From: Lowen, Stuart [mailto:slowen@ballcolegrave.com]
Sent: 11 April 2018 12:01
To: DC Support
Subject: FW: Amended Planning Application 18/00220/F comments from Colegrave Seeds Ltd
Importance: High

We have received another neighbour notification regarding the amended **Planning Application 18/00220/F**.

Re – Planning Application 18/00220/F – Comments from Ball Colegrave Ltd

REV C 04/07/18

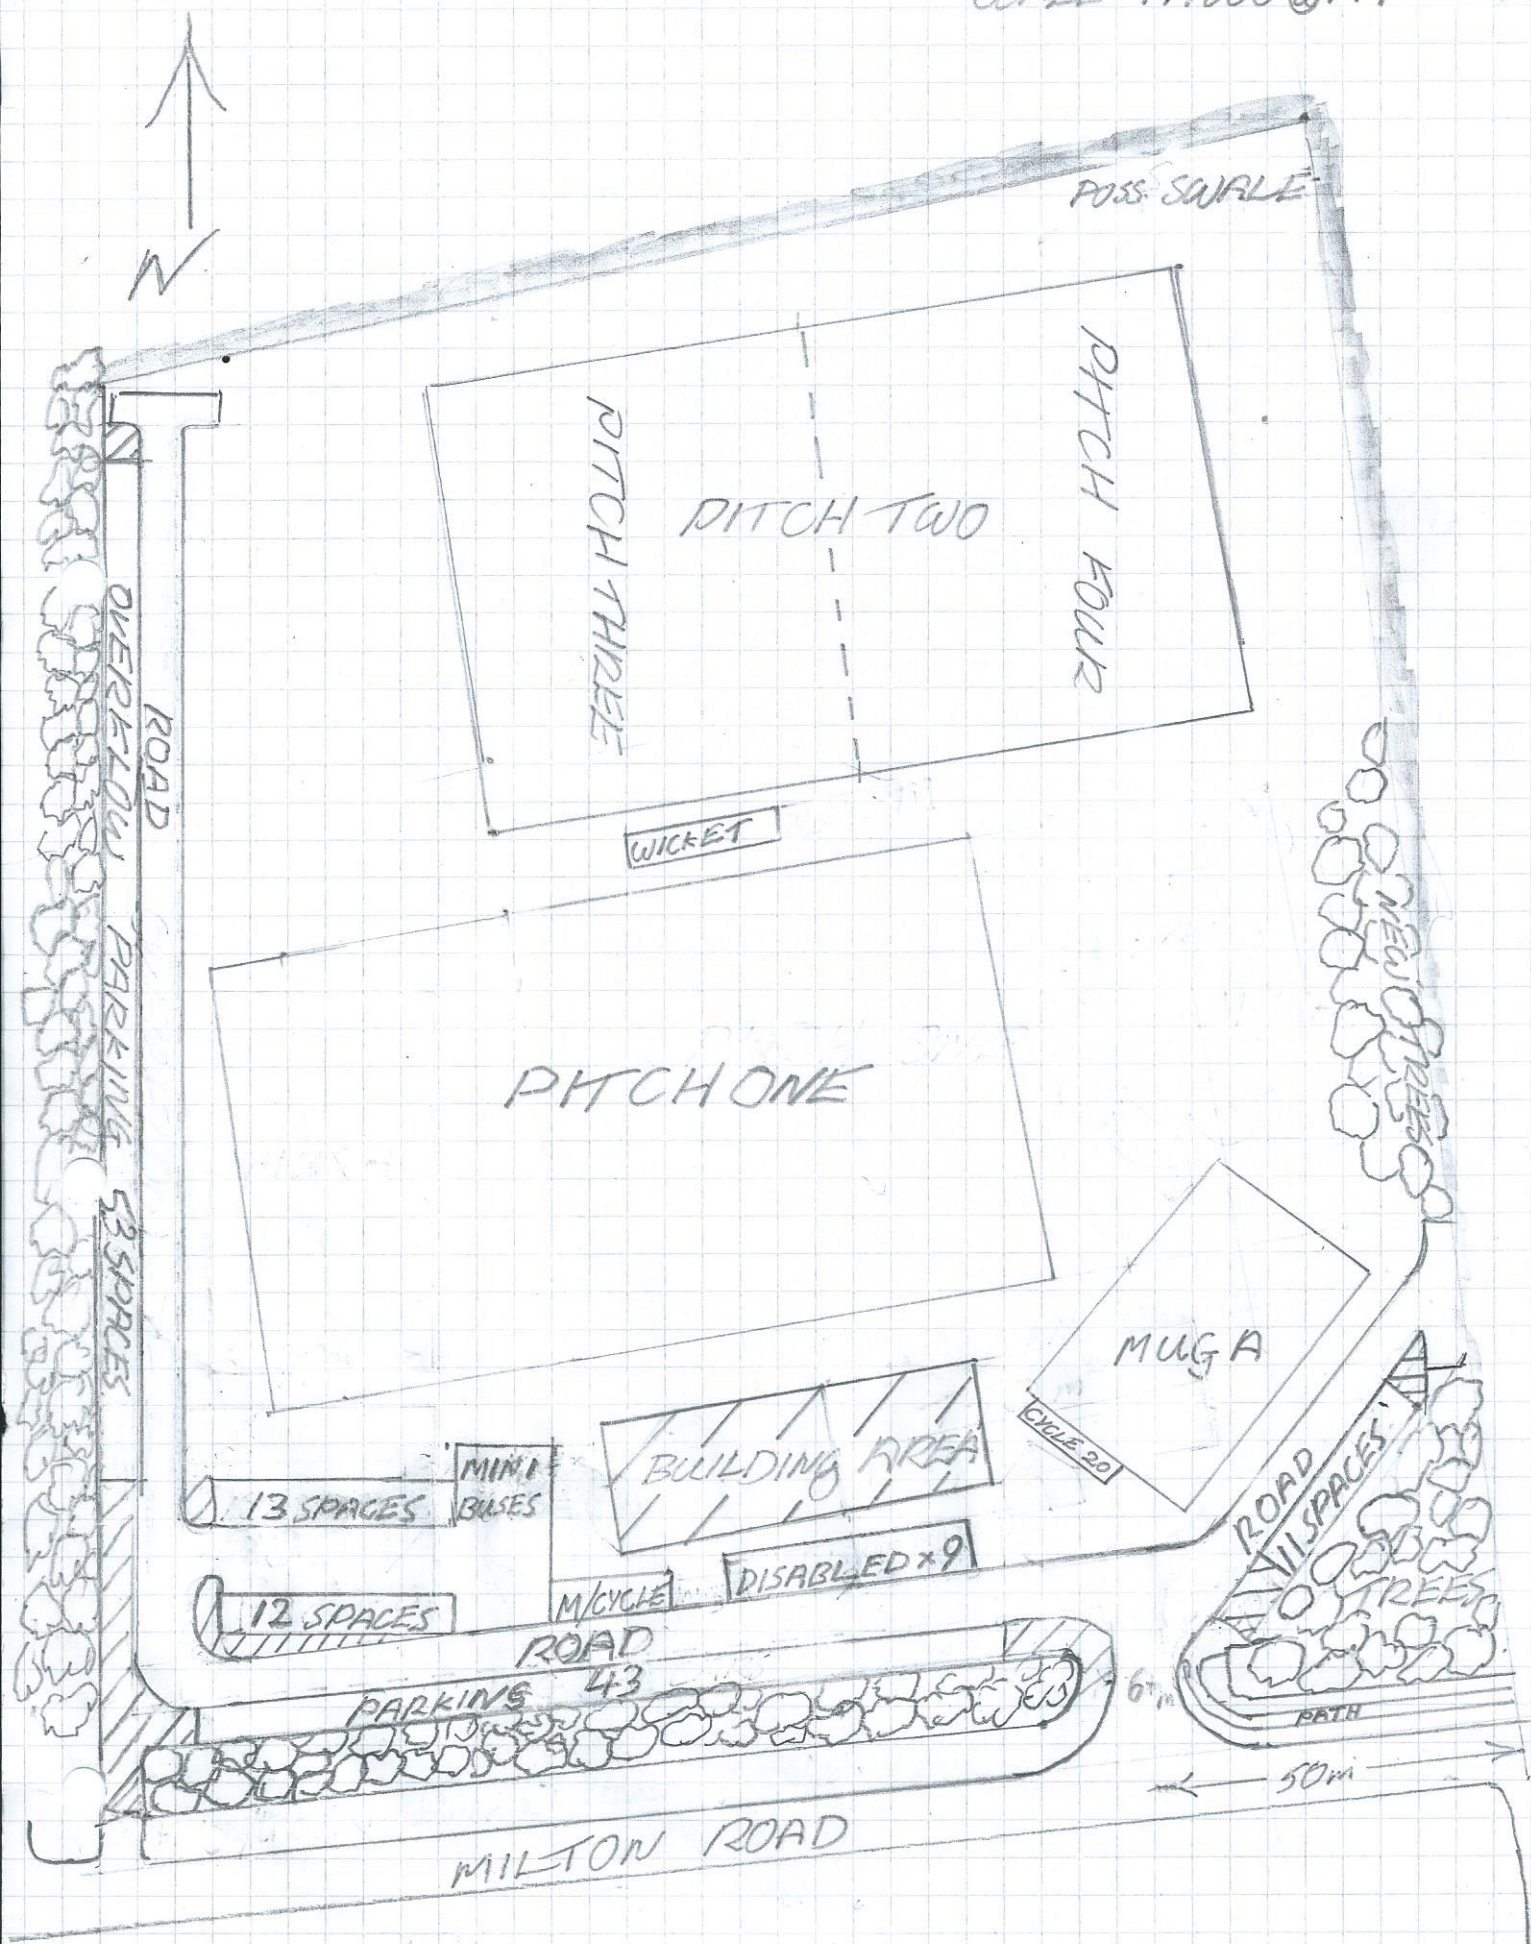
- Security - We have serious concerns to the security of our property with the proposed parking area and MUGA play areas so close to our boundary line. I would like to see a proposal from the new land owner as to how the public using this facility are going to be kept off our land. I recommend a substantial high chain fencing needs to be installed along the full length of the boundary line.

- Balls - The use of cricket and other balls is our second major concern. The loss or damage to the plants in our Greenhouses through stray balls could have far reaching effects and consequential damage to our business as this include International Breeding Trials. Again we need assurance that everything practical is being done to avoid such a situation occurring. High chain fencing may be part of this solution.

- Light Pollution- The third major concern is light pollution. Our trials site was carefully chosen as a safe distance away from light pollution. Street lights and floodlights will have a potentially disastrous results on the development of the plants growing in our nursery, changing their mode and timing of flower. This again may cause consequential damage to our business. We need assurances that floodlighting will not be used in this area overnight and any small amounts of security lighting deflected away from the direction of our greenhouses.
